20 December 2021

TfNSW Reference: SYD21/00981/03

Departments Reference: SSD-25725029

**EXHIBITION OF EIS – ARDEX WAREHOUSE & MANUFACTURING FACILITY –
657-769 MAMRE ROAD - KEMPS CREEK**

Figure 12: Traffic Volume Distribution for the MSP Ultimate Plan and Southern Lots GFA for 2026

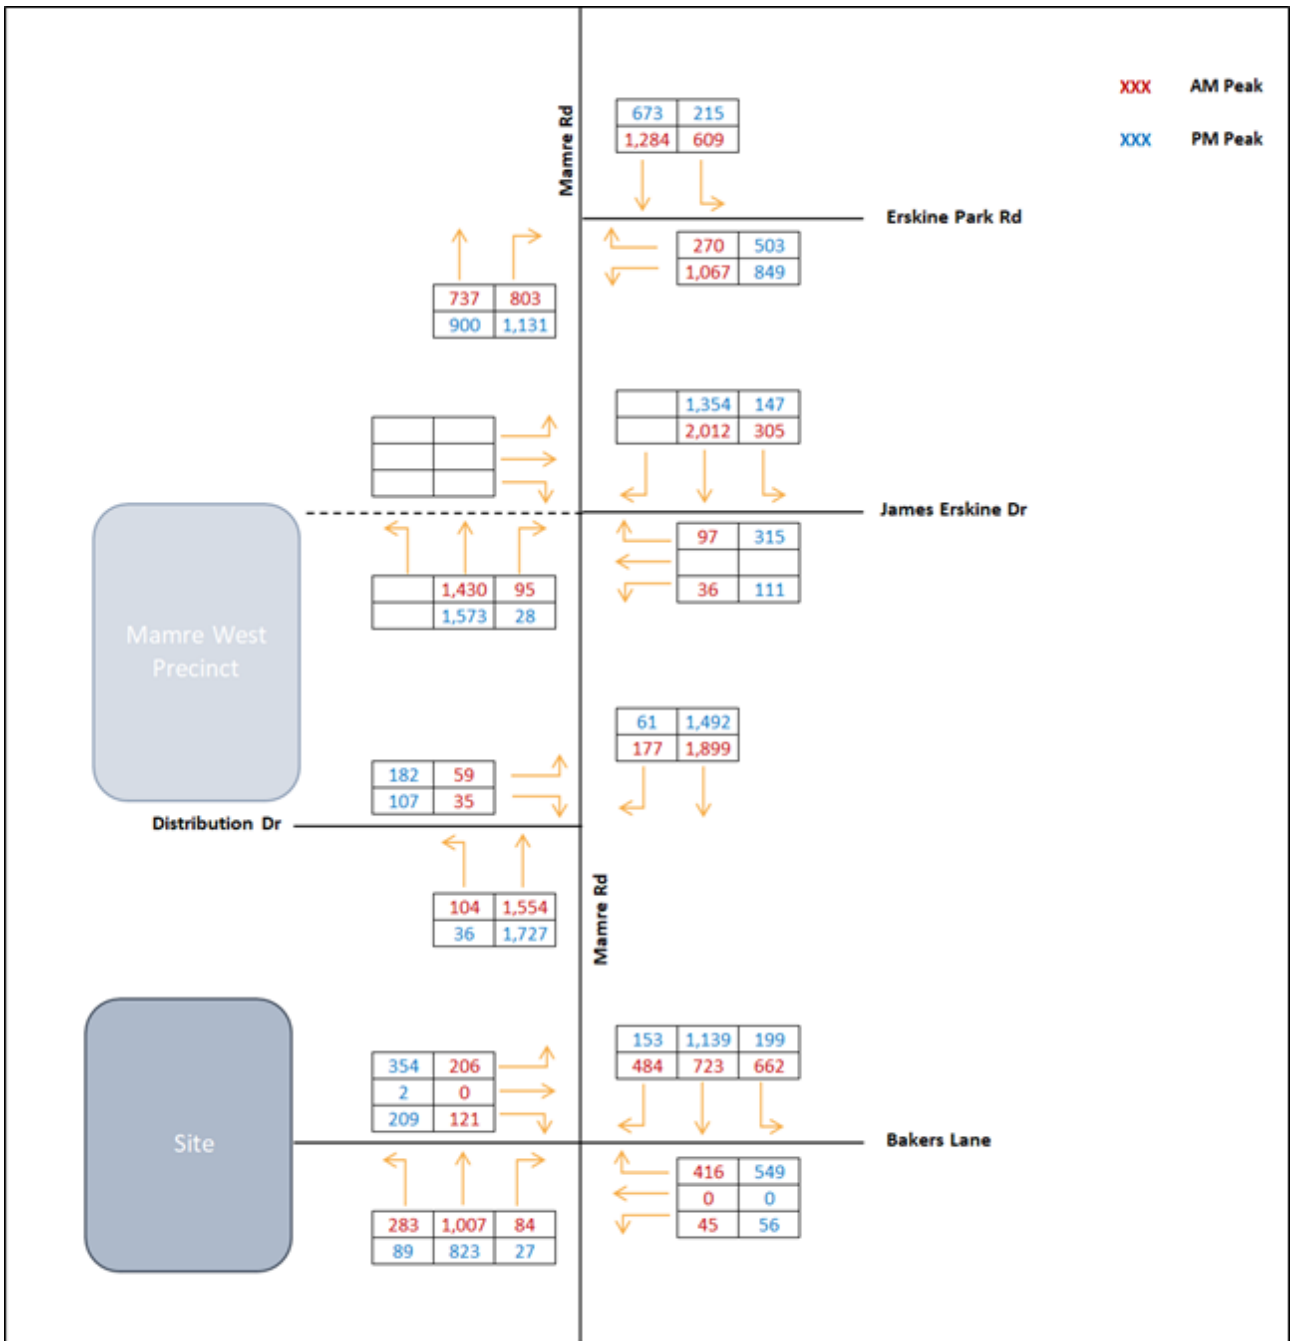
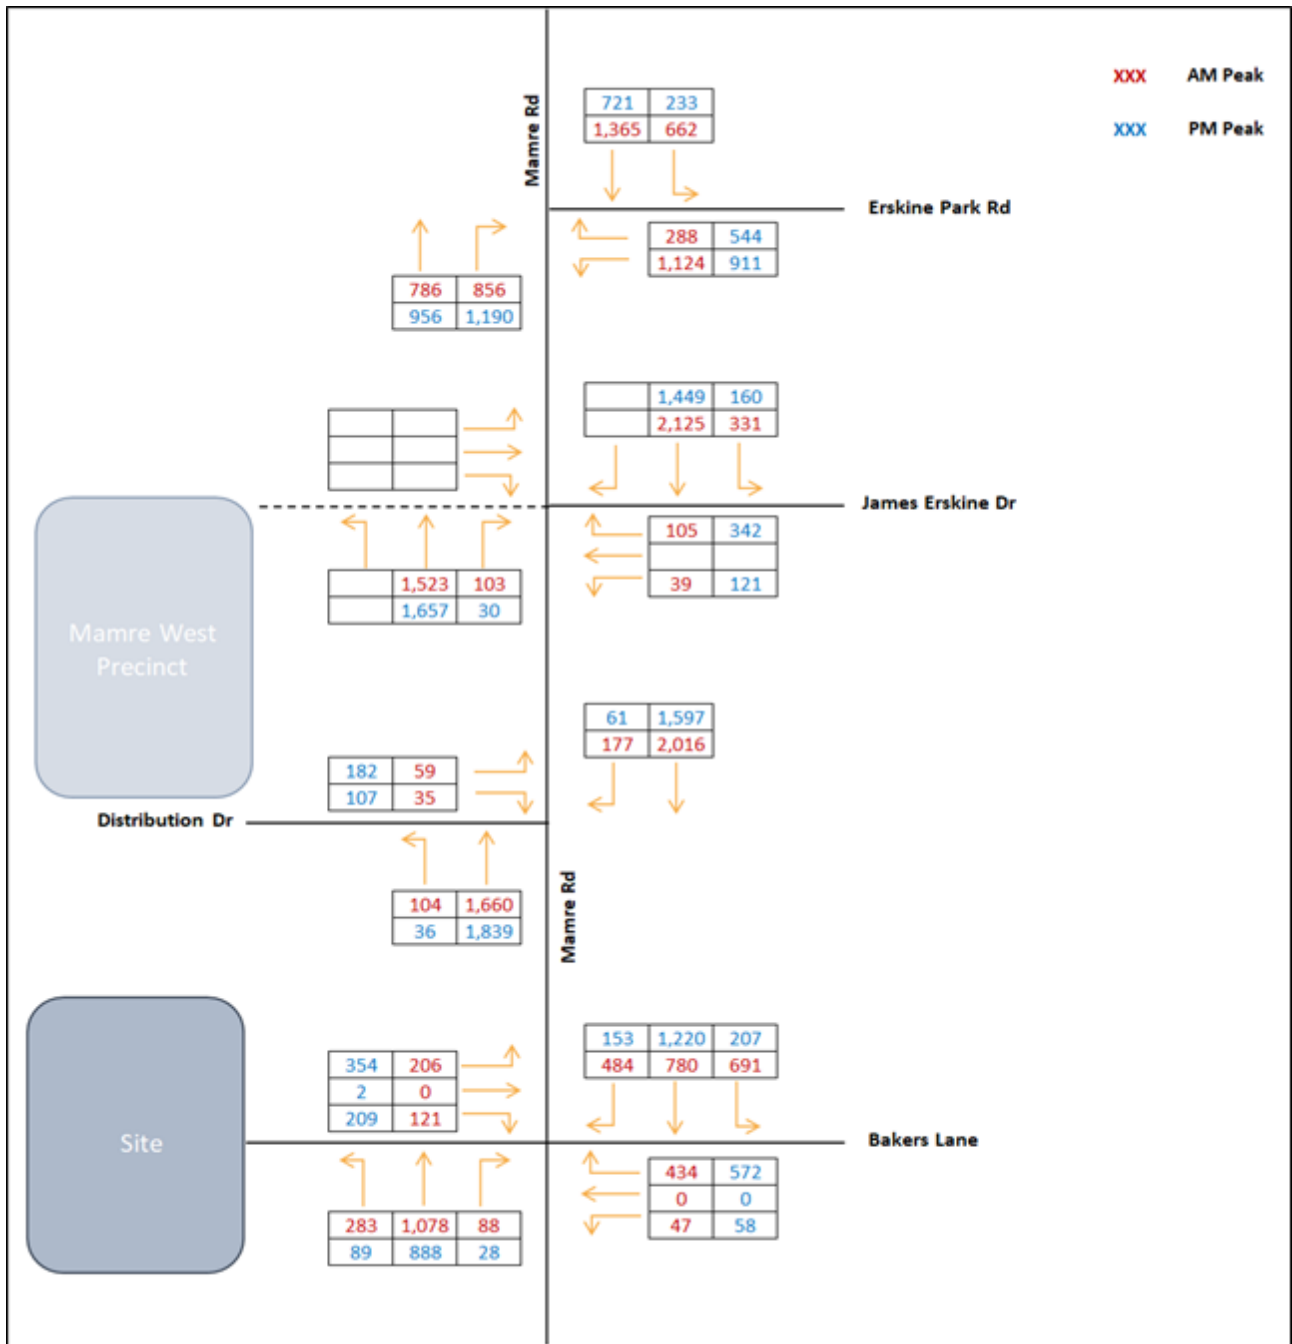
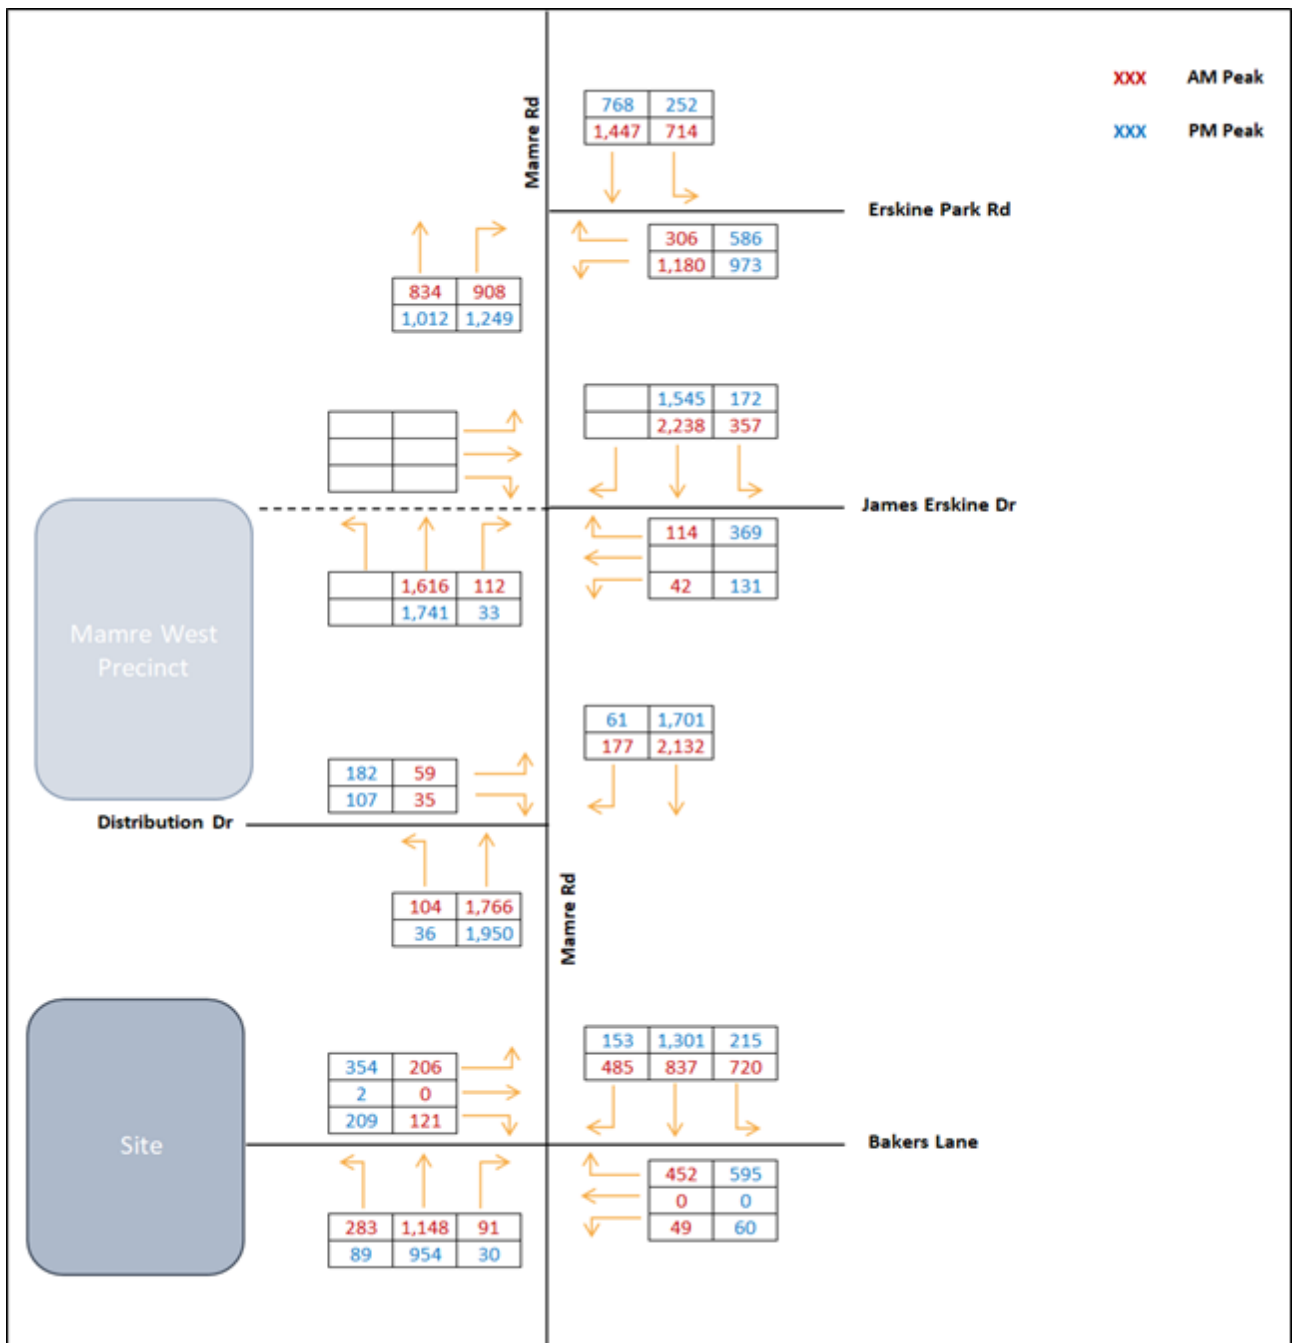
Section 6.1 – Figures 12, 13 and 14 demonstrate that there is no increase in traffic volume in and out of the site for 2026, 2031 and 2036.

It is recommended that clarification is provided to understand why the volumes do not increase.

Figure 16: Potential Intersection Layout (Signalised Intersection) for SLR / Bakers Lane (in 2036)

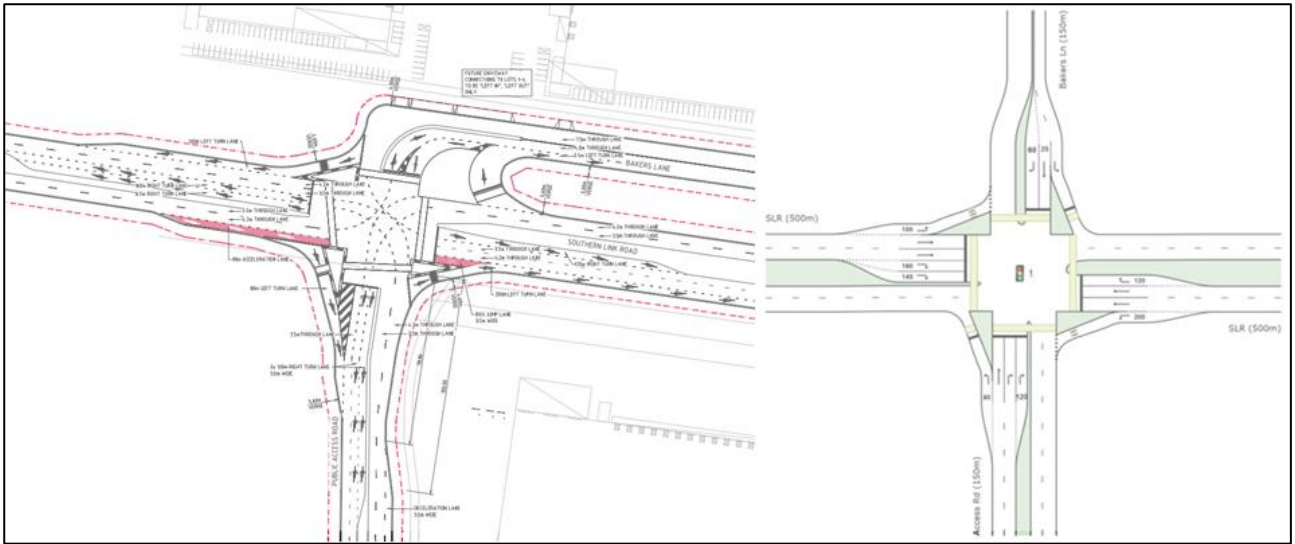
Section 6.7 - *future SLR /Bakers Lane/NS Road 01* - It should be noted that the layout of this intersection is not supported by TfNSW. TfNSW has provided preliminary guidance on the 3 November to the applicant and DPIE regarding the layout and modelling of this intersection (**Attachment B**). This guidance was given to the applicant based on the following condition (B18) for SSD 9522 (Masterplan):

As TfNSW does not support the intersection design the modelling inputs for the 2036 year model are not supported.

In order to provide accurate assumptions for 2036 model, it is recommended that the applicant continue to develop the intersection design relating to SSD 9522 Condition B18 in consultation with TfNSW.
